Rezoning Transportation Analysis

Petition Number: 2022-192

Revision Log:

Date	Description
3-22-23	First Review (TM)
04-20-23	Second Review (TM)

RZ-1.0

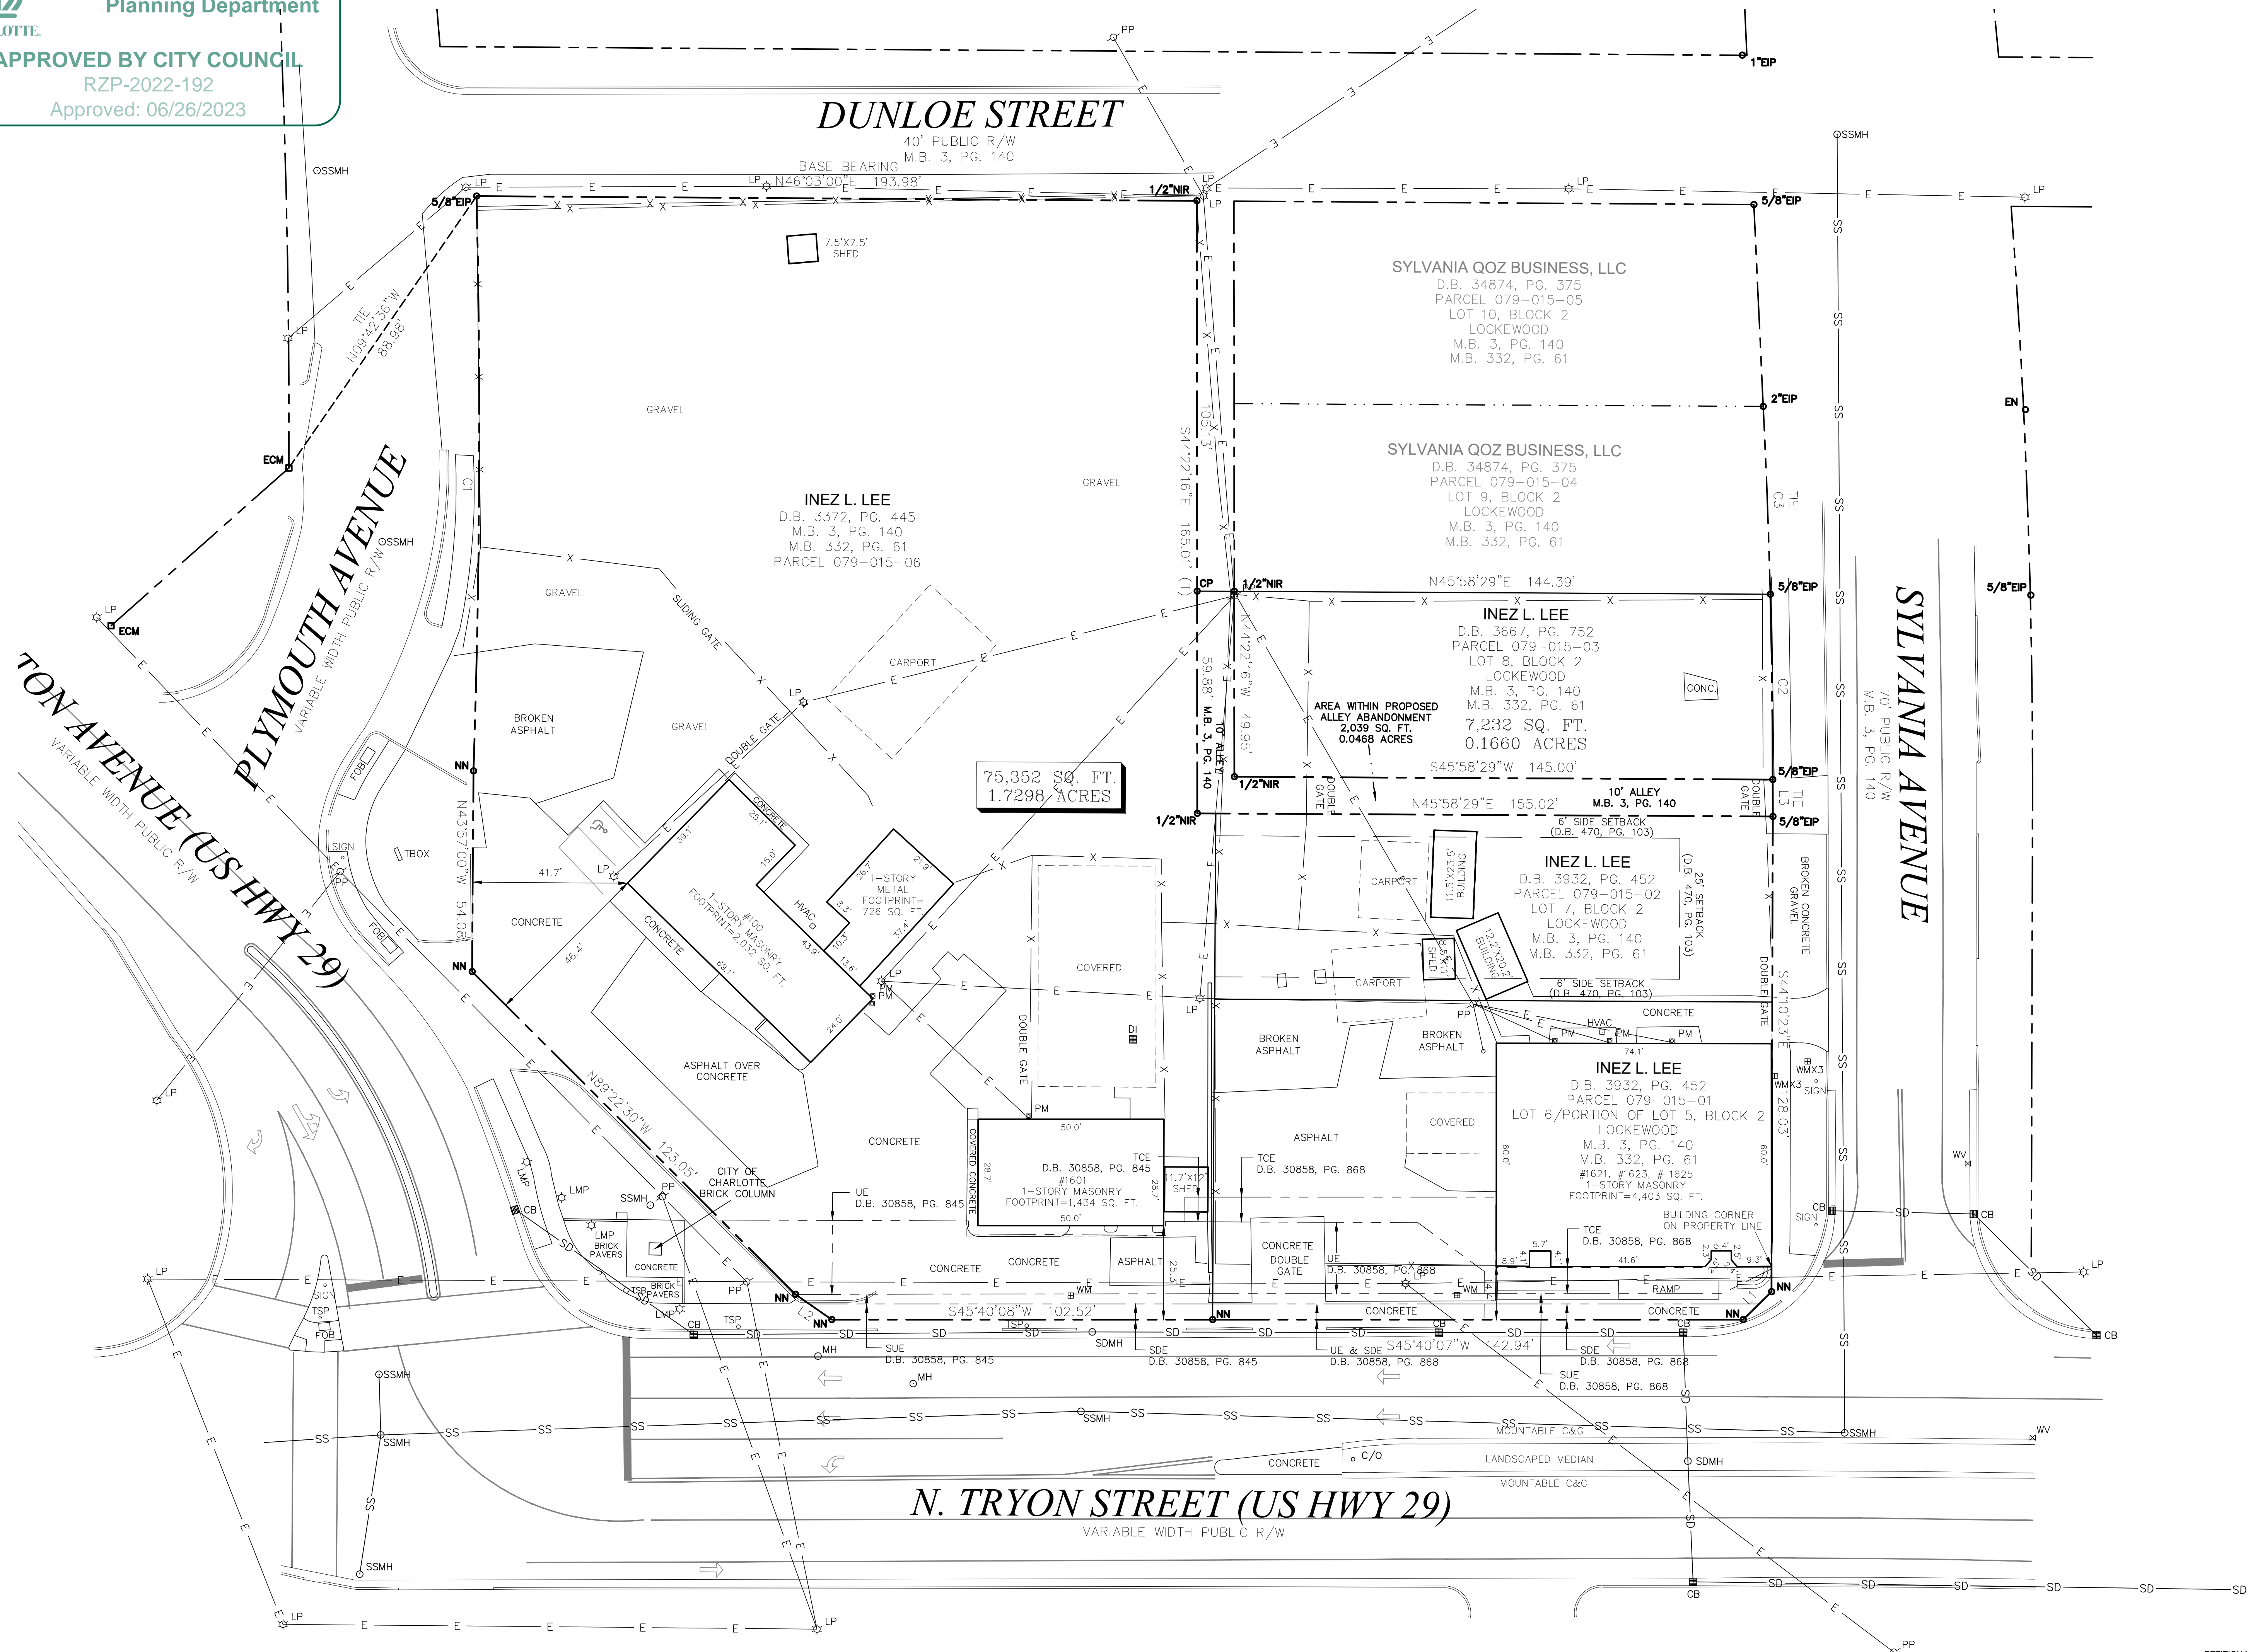
b. **Dalton Street:** location of future curb and gutter to be moved 35-feet from roadway centerline to accommodate the Charlotte Streets Map with a roadway section of 4+ Avenue and Bike Lanes. Add conditional note that the curb line location is to be finalized during permitting in coordination with CDOT to accommodate Charlotte Streets Map.

Clarifying Comment from 04-20-23: Add conditional note that the curb line location is to be finalized during permitting in coordination with CDOT to accommodate Charlotte Streets Map.

11. **Outstanding Comment from 03-22-23:** Revise site plan and conditional note(s) to commit to construct bicycle facilities by locating the curb and gutter 35-feet from the Dalton Street center line and installing bike lanes on Dalton Street to meet the Council-adopted Charlotte BIKES Policy.

Clarifying Comment from 04-20-23: Add conditional note that the curb line location is to be finalized during permitting in coordination with CDOT to accommodate Charlotte Streets Map.

- ~~13. Revise site plan and conditional notes to state that final location of shared access alley to be coordinated during permitting.~~
- ~~14. Revise site plan by placing the 50x50 CDOT sight triangle and 10x70 NCDOT sight triangle in the proper location on the site plan.~~
15. **Outstanding Comment from 03-22-23:** Revise site plan and conditional notes to commit to revising existing curb ramps along site frontage to meet current standards. Landing strip/Truncated dome width must match width of sidewalk being installed.

Clarifying Comment from 04-20-23: Add conditional stating that all curb ramps along the sites frontages shall meet current CDOT/NCDOT standards for design.

19. Add a conditional note specifying "All transportation improvements will be approved and constructed before the site's first building certificate of occupancy is issued. The petitioner may phase transportation improvements if said improvements and phasing are explicitly described in site plan notes."

Clarifying Comment from 04-20-23: Revise conditional notes by stating that transportation improvements will be approved as well as constructed prior to the first certificate of occupancy.
